SUTHERLAND SHIRE COUNCIL SUBMISSION TO SSD-10412, BREEN RESOURCE RECOVERY FACILITY

PART 2 - ENVIRONMENTAL ASSESSMENT AND RESPONSE TO SEARs

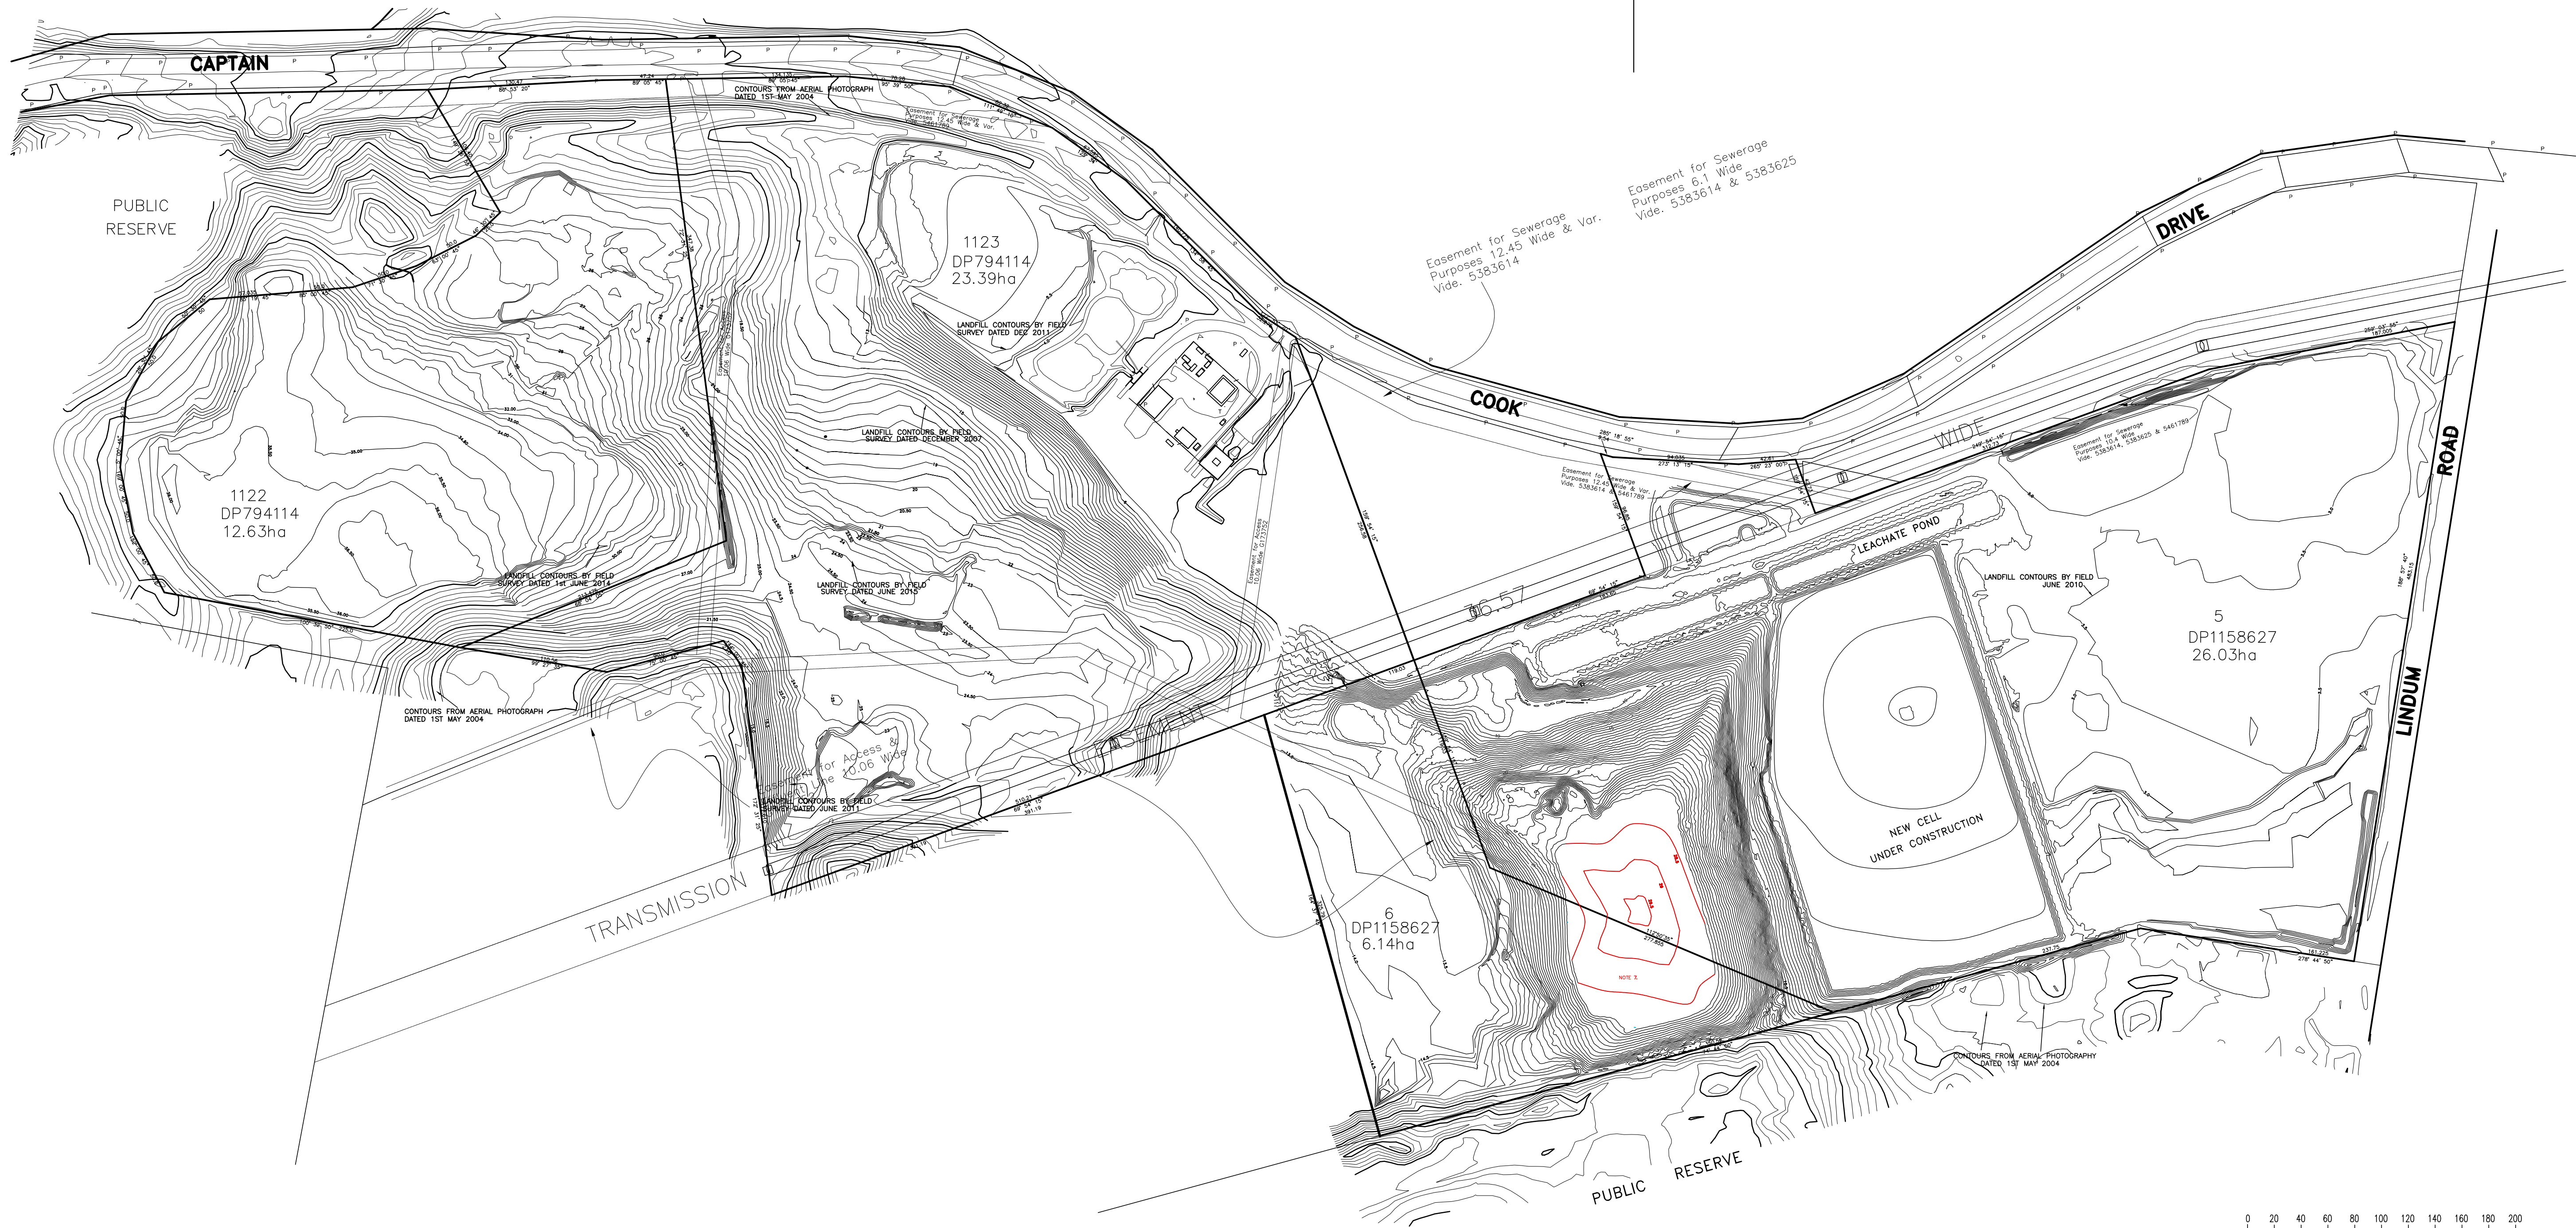
The survey plan provided lacks detail in relation to specific aspects of the site including the neighbouring road reserve. Many of the survey detail relied upon is historic and given the nature of the use of the land has likely changed overtime.

Figure 2-3 Proposed Site Plan – New Resource Recovery Facility

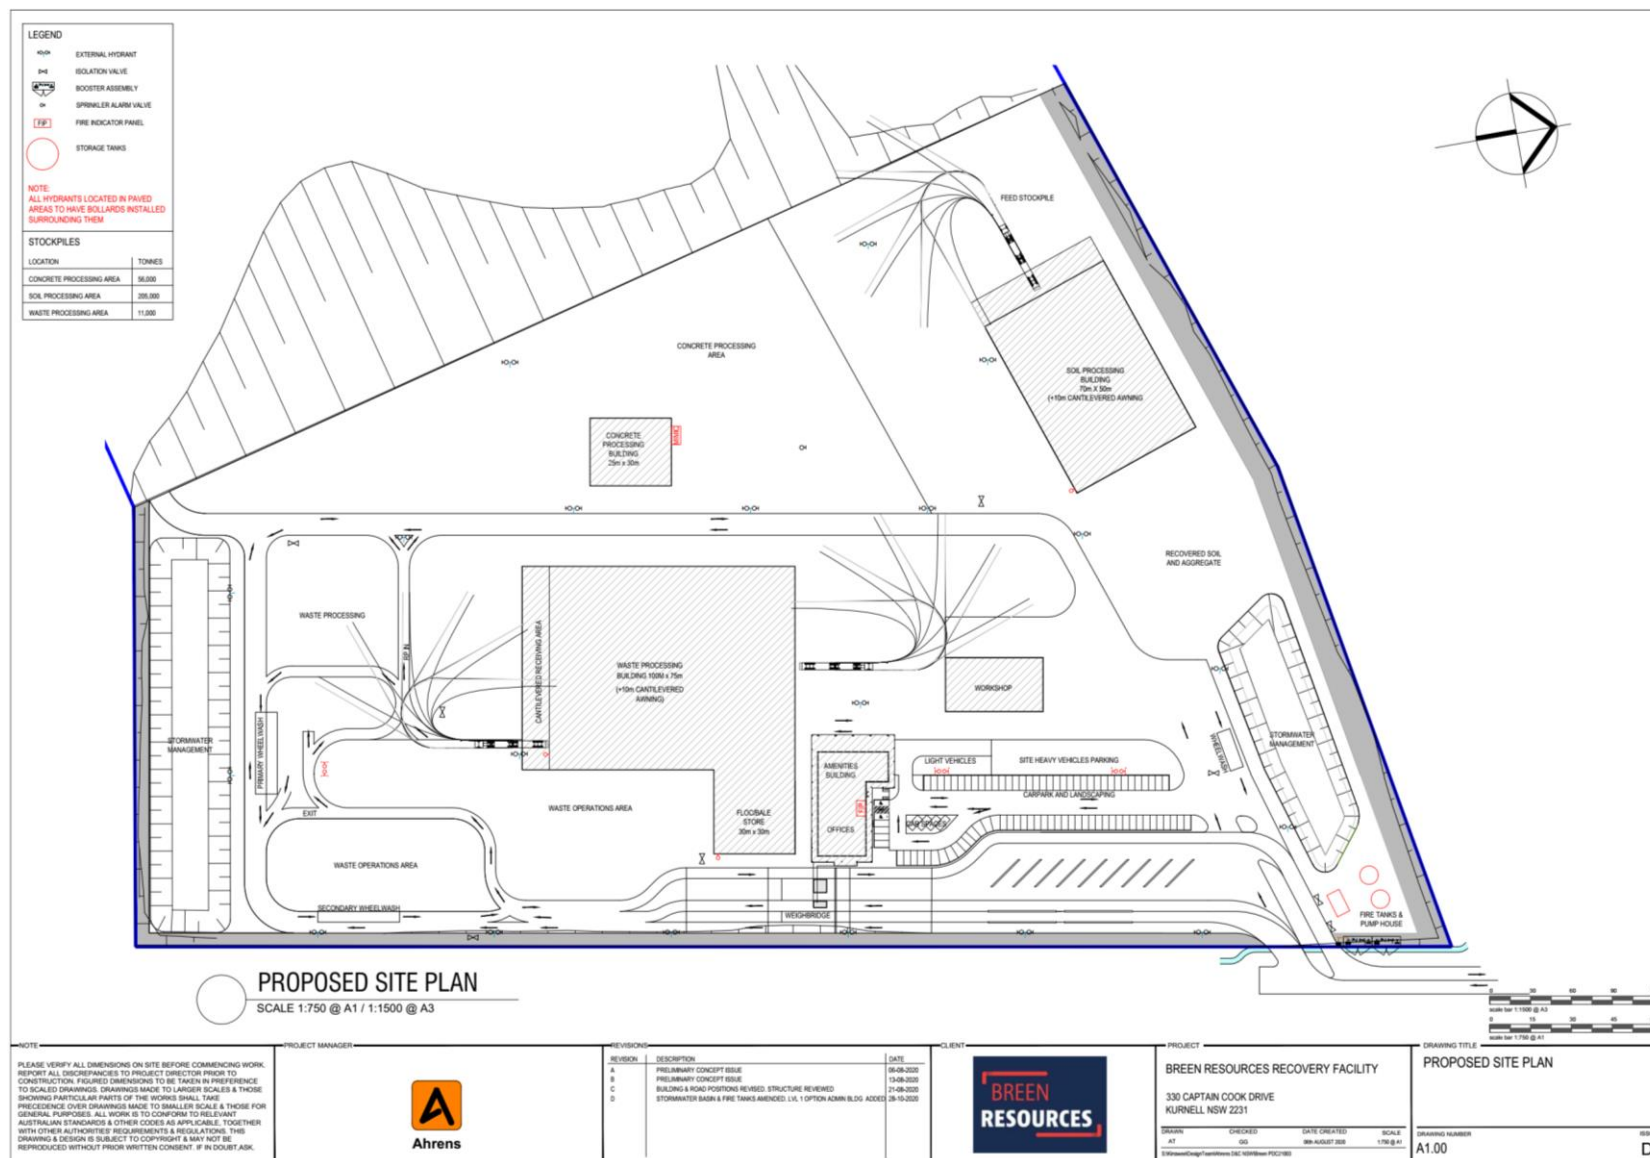
The quality of the landscape submission for the resource recovery component of the development is poor and lacking in detail. Generally speaking, existing levels within the site have been highly modified. It is essential to understand the intended finished levels of the development as batters & retaining walls may be required across the site to maintain those existing contours on the boundaries. The landscape plan should assign finishes across the entirety of the sites ground plane.

In section and elevation within the Architectural drawings the ground level is shown flat. The ground levels within site have not been designated an RL nor has an FFL been designated to buildings. With finished levels unknown across site, the buildings could be perceived even larger when looking from the surrounds if levels are raised internally.

The area designated as landscape buffer to the north is appropriate at 12m wide, this will allow adequate room for meaningful tree planting and screening. Areas designated as landscape buffer to the east & south at 6m are inadequate. The processing sheds are notated in the Architectural Plans at 14.4m tall in elevation (4.5 stories). Buildings of this scale require a minimum landscape setback of 12m if to be properly screened.

As the site is housing large new infrastructure and machinery it is crucial to know the locations of above and below ground services. As these may have a detrimental or limiting effect upon landscaping especially power & stormwater services. Services should be required to remain outside of the landscape buffer areas.

Further, the amenities building should have an external breakout space for future employees which includes seating, landscaping, shelters. Trees designated amongst the car parking area in blisters will require irrigation & structural soil at a minimum. The site is very exposed to sunlight and salt winds. Details of these tree blisters should be required. The planting scheme should reflect what is shown in the other stages of the development, utilising hardy endemic species from the Kurnell Dune Forest Community. Irrigation will be necessary to all areas designated as landscape.
